Date: 15-Apr-2026
Our Ref: 2026/90780

**Application for a non-material amendment following a grant of planning permission,
Town and Country Planning Act 1990**

**Non material amendment to previous permission 2025/93073 for erection of first
floor side extension, hip to gable, dormer and associated works
7, Woburn Drive, Waterloo, Huddersfield, HD5 0AQ
Application Number: 2026/90780**

Project: 7 WOBURN DRIVE WATERLOO, HUDDERSFIELD	Job No: 2025-011
Title: PROPOSED PLANS & ELEVATIONS	
Scale: 1:50@A1	Drawn by: AP
Date: MAY 25	Checked by: -
Drawing No: 2025-006(20)002	Revision No: -

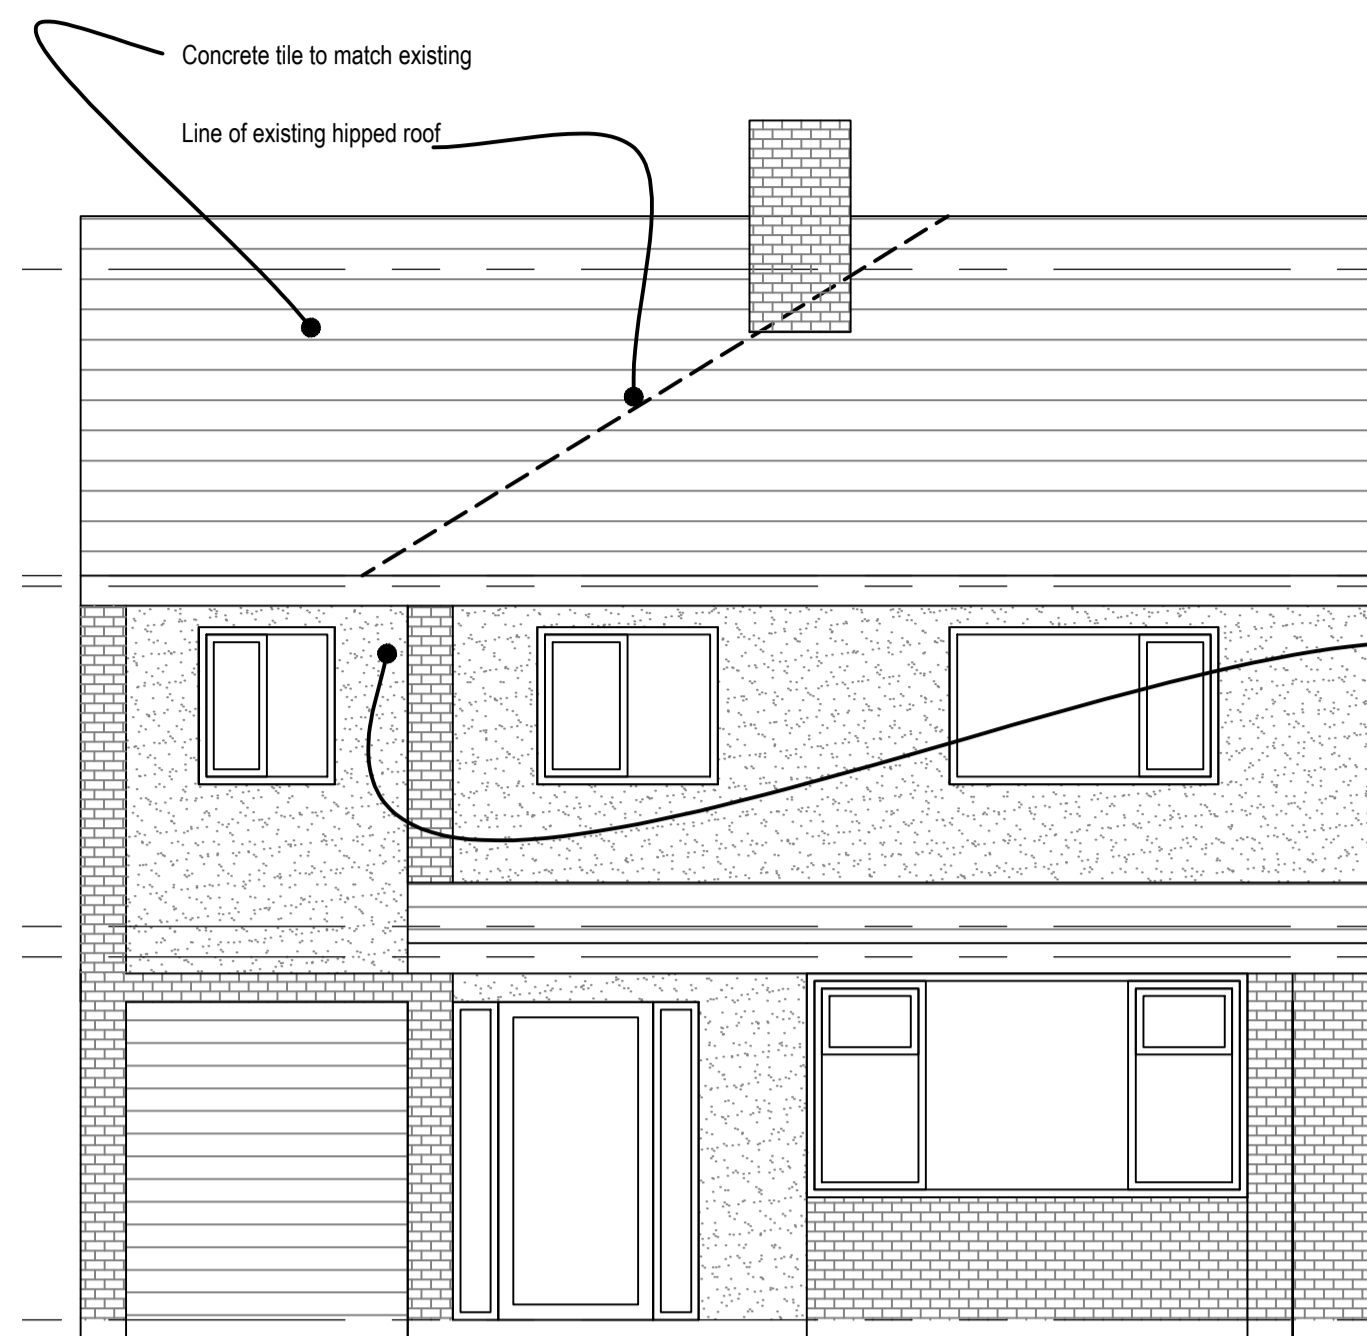
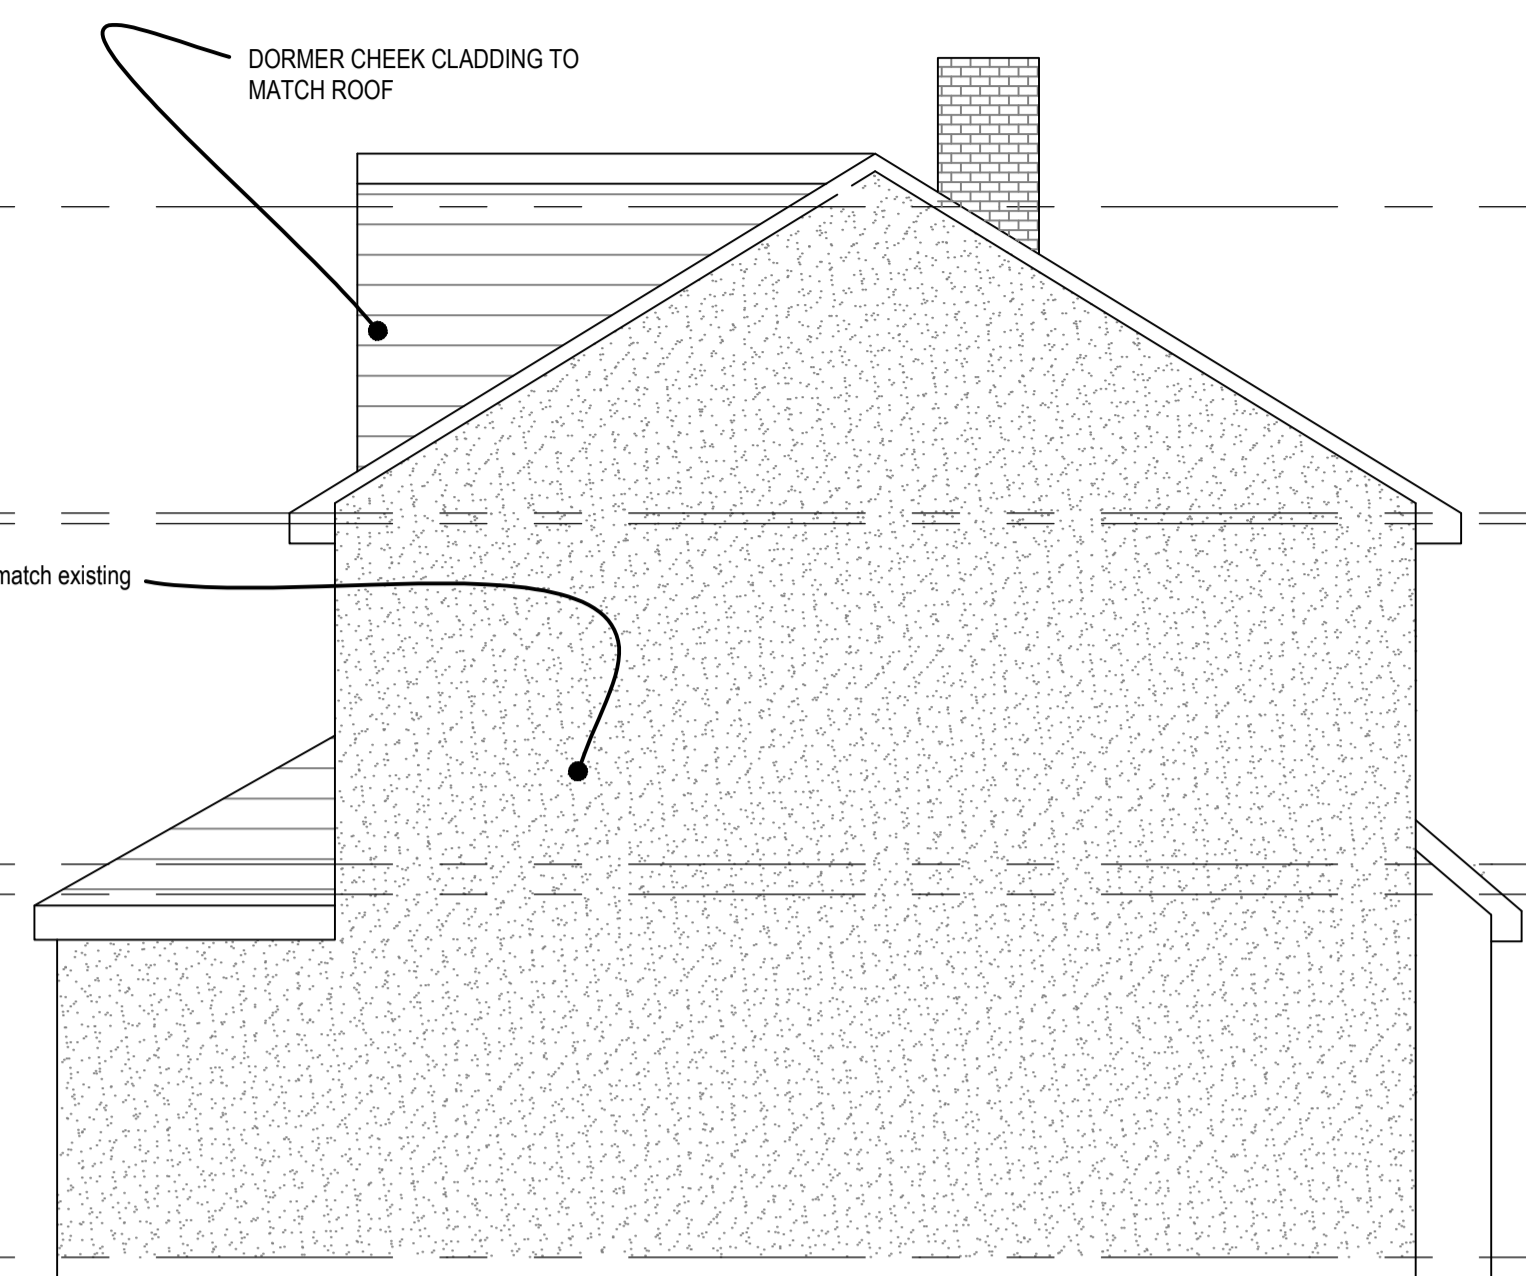
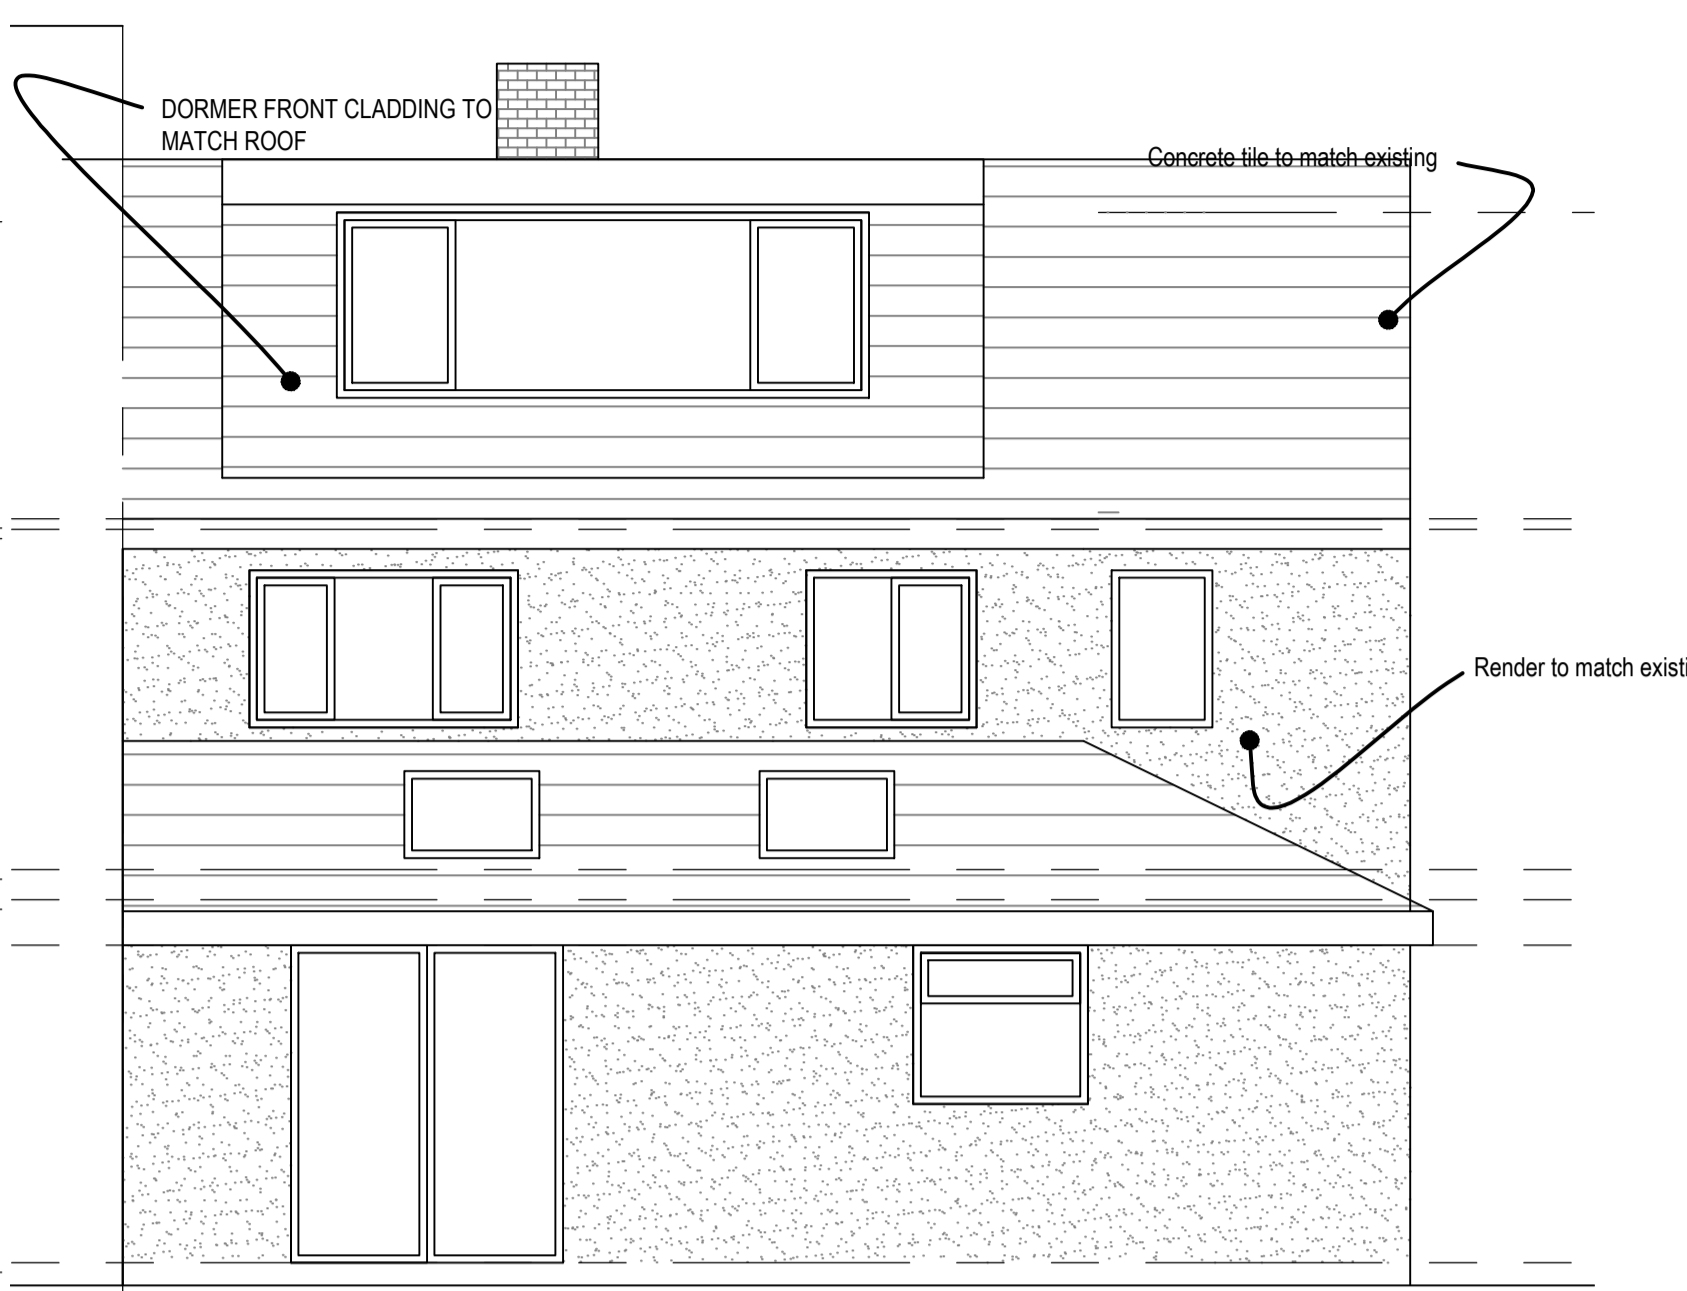
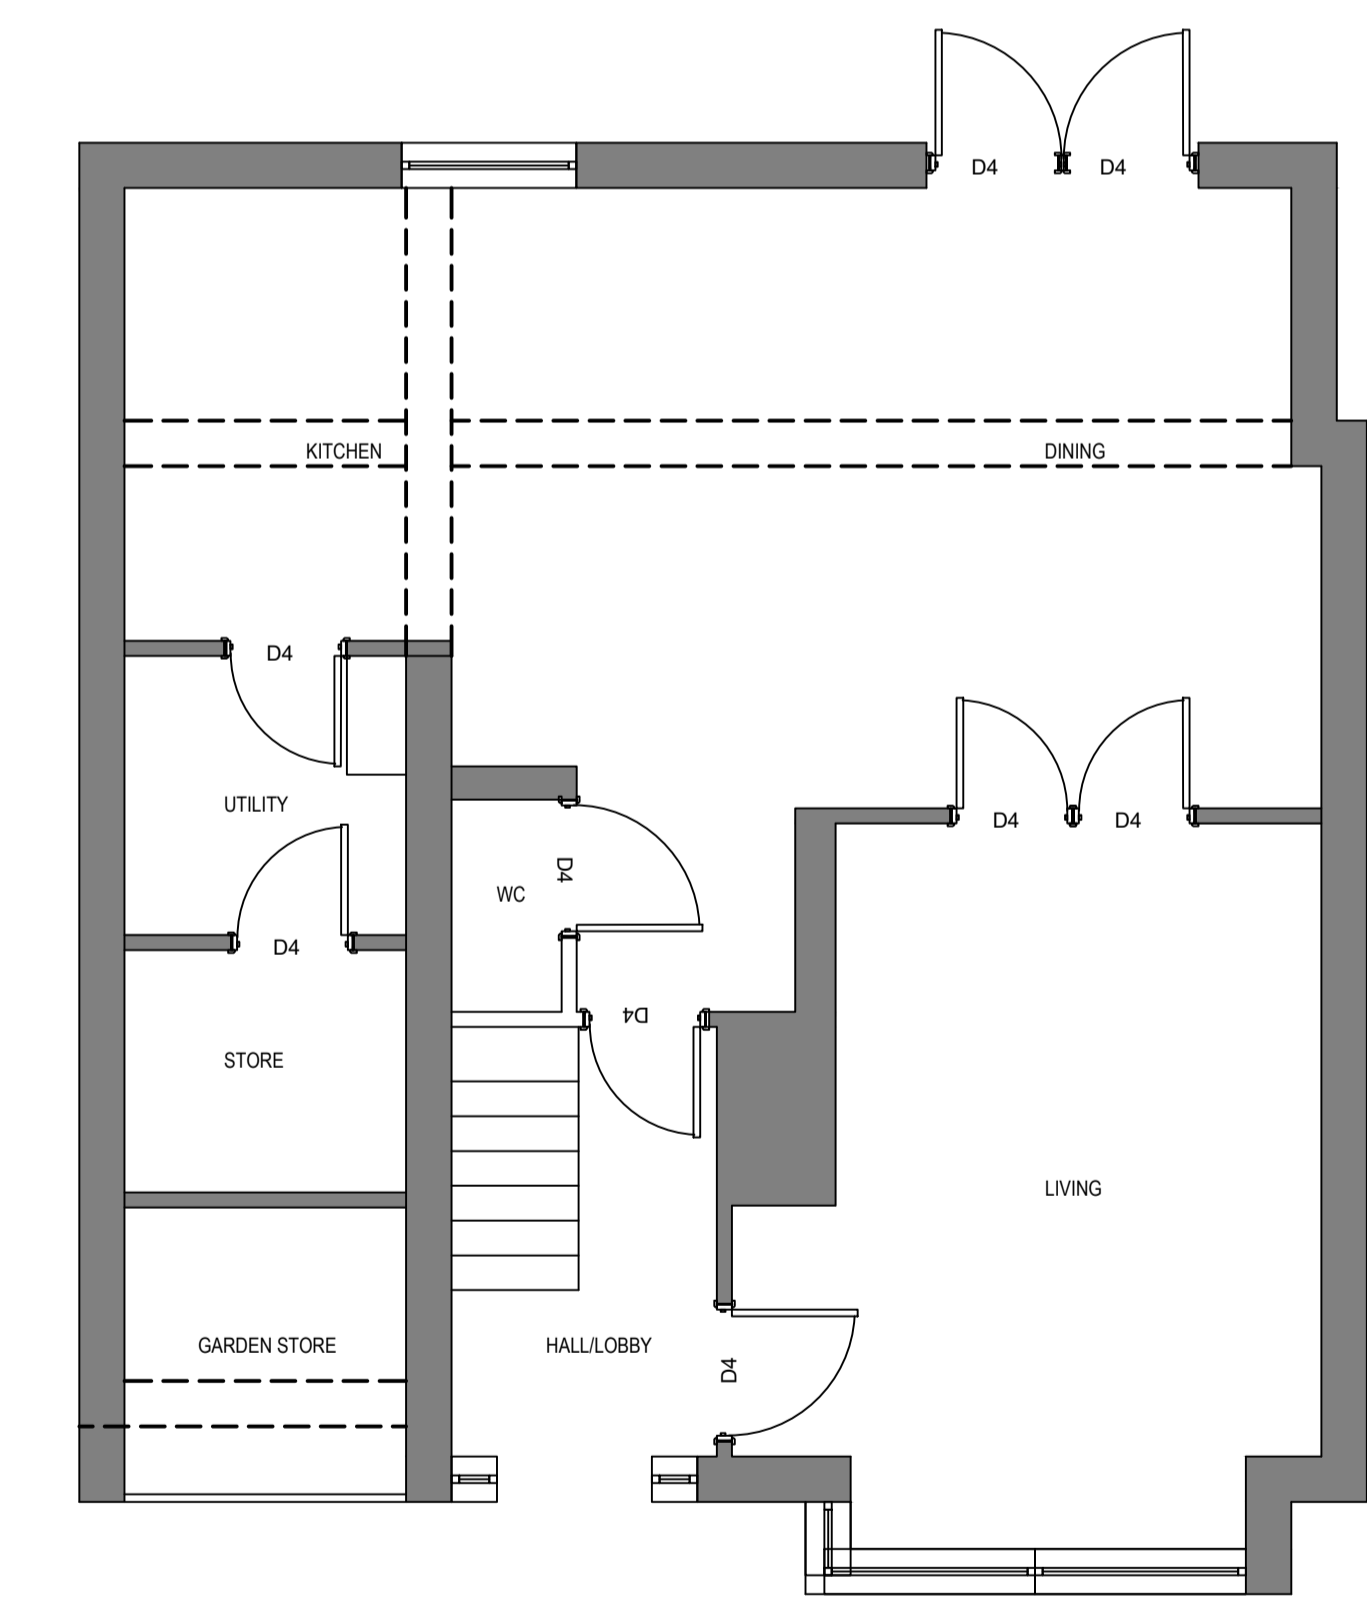
I am only able to consider non-material amendments to plans approved under a previous planning permission which are minor and do not materially change the appearance or character of the previously publicised scheme. The proposed alterations to the approved plans extend beyond this and hence I am unable to accept them. A new application will be required which will be subject to a further round of publicity and consultation.

The amendments shown on plan reference 2025-006(20)002 would not appear subservient to the host and contrary to current policy set out in the Local Plan and House Extensions and Alterations SPD.
